**M5 JUNCTION 10 IMPROVEMENTS SCHEME – TR010063**

**Section 51 advice regarding draft application documents submitted by Gloucestershire County Council**

On 18 November 2022, Gloucestershire County Council submitted the following draft documents for review by the Planning Inspectorate as part of its Pre-application Service<sup>1</sup>:

Figure 4.1 – West Cheltenham Link Road Route Corridors

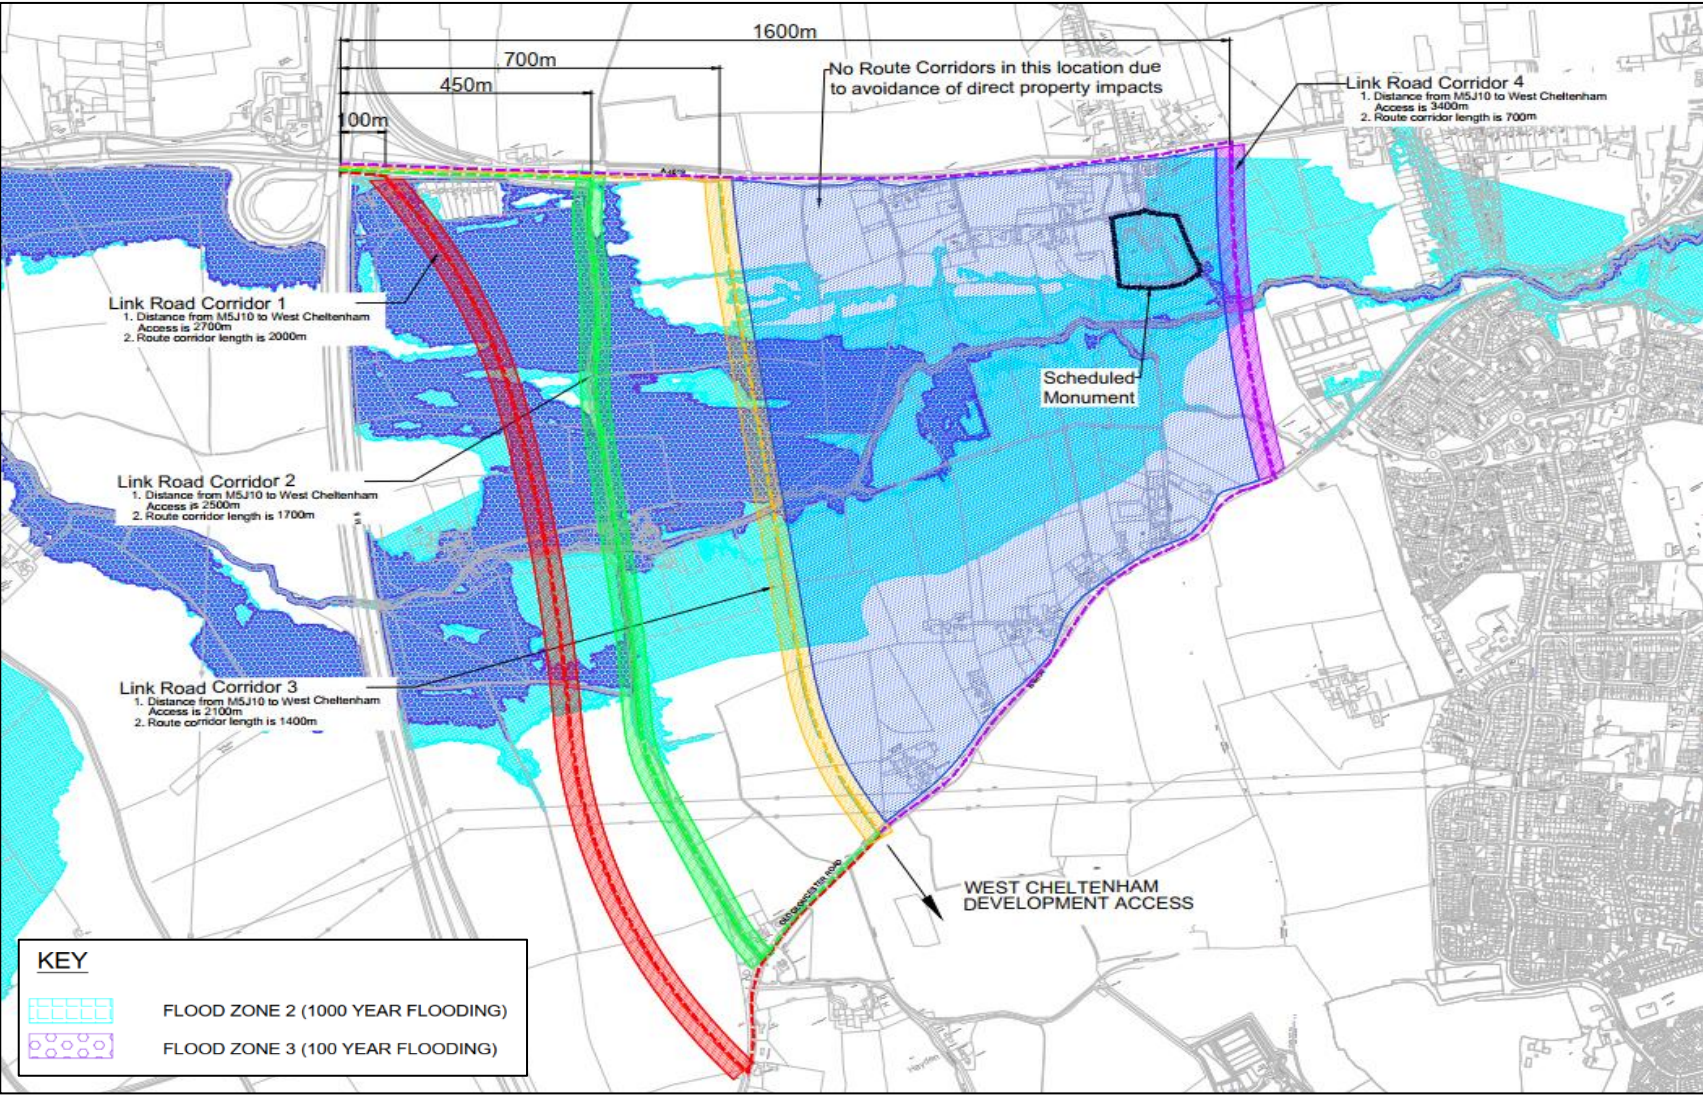
37.	Figure 3-2	The Applicant may wish to clarify the title of this figure to make clear this represents the “Options 1A, 2, 2A, 2B and 5 for the M5 Junction 10 Improvements Scheme (without earthworks)”, as stated in the ES.  The Applicant may also wish to include Figure 3-3 “West Cheltenham Link Road Route Corridors” as a standalone figure rather than embedded in the ES text, for clarity.
